From: Simon Davis <Simon.Davis@arun.gov.uk>
Sent: 30 October 2019 15:39
To: Planning.Responses <Planning.Responses@arun.gov.uk>
Subject: FW: AL/51/19/PL Springfield, Hook Lane, Aldingbourne

Further Drainage Engineer consultation comments

From: Sarah Burrow <Sarah.Burrow@arun.gov.uk>
Sent: 30 October 2019 15:25
To: Simon Davis <Simon.Davis@arun.gov.uk>
Cc: [REDACTED]
Subject: RE: AL/51/19/PL Springfield, Hook Lane, Aldingbourne

Drawing Title		Drawing No.	
Engineering Details		KNC1932	
Drainage Strategy		602-01	
Drawn	Checked	Scales	Page Size
KN	KN	1:250	A1
Job No.	Drawing No.	Date	Revision
KNC1932	602-01	09.19	A

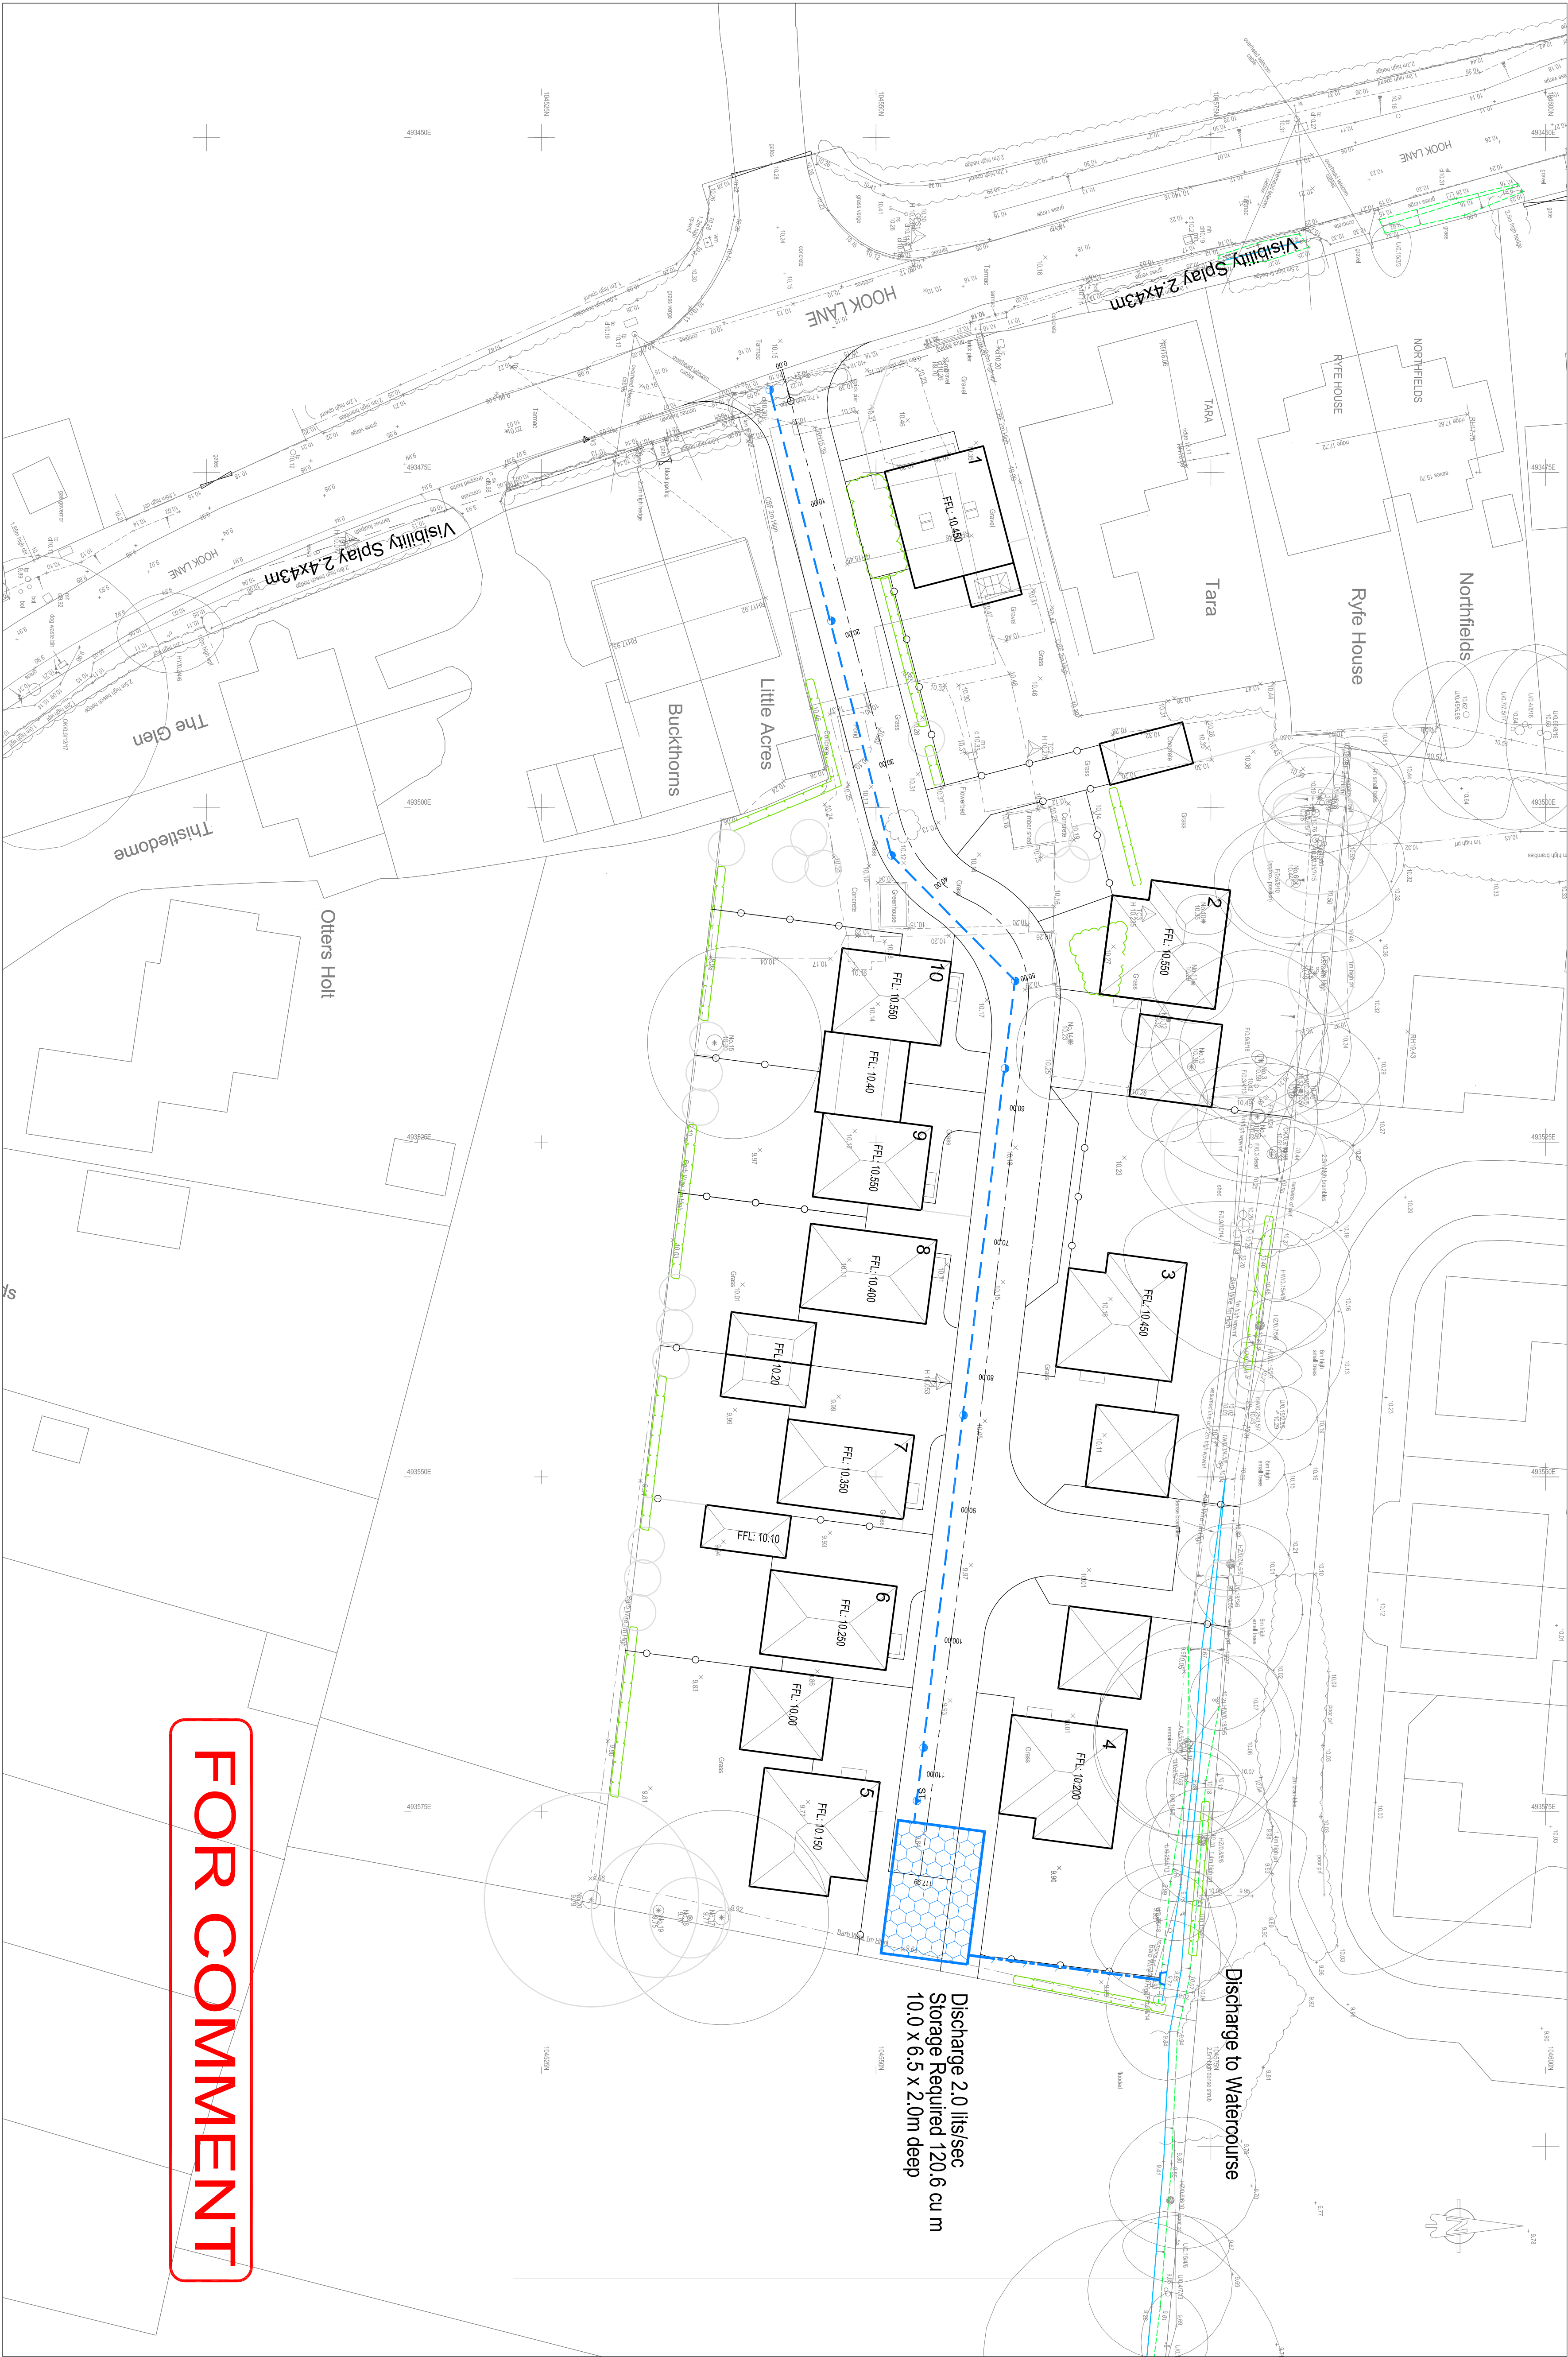
1. A full winter's (November to March inclusive) groundwater monitoring will need to be completed on the site in order to establish peak groundwater.
2. Further infiltration testing will need to be completed in accordance with BRE365 to a depth above the highest recorded groundwater. For a development of this size we would expect a minimum of 5 trial pits, evenly distributed across the width and length of the plot. The infiltration tests that have been completed are not sufficient in number or to an appropriate depth, particularly given that Laura had already stated that groundwater was expected to be high in the area. In addition the infiltration rate f , is given as "#DIV/0!".

3. The surface water drainage strategy for the site will be dictated by the results of the testing and the hierarchy of preference for different types of surface water drainage disposal systems as per condition **PCENG D2** below. Therefore if infiltration is viable to a shallow depth then this shall be prioritised over attenuation.

4. If necessary the council will consider a hybrid solution to maximise infiltration potential.
5. We do not support pumping as it is not a sustainable solution, therefore every effort will have to be made to establish a gravity solution if attenuation and discharge is used.

6. Depending on the results of the groundwater monitoring it may be necessary to provide a counter to buoyancy in any attenuation solution.
7. The applicant is reminded that all houses, fences and walls must be kept at least 3m from the top of the bank of the watercourse on the northern boundary of the site.
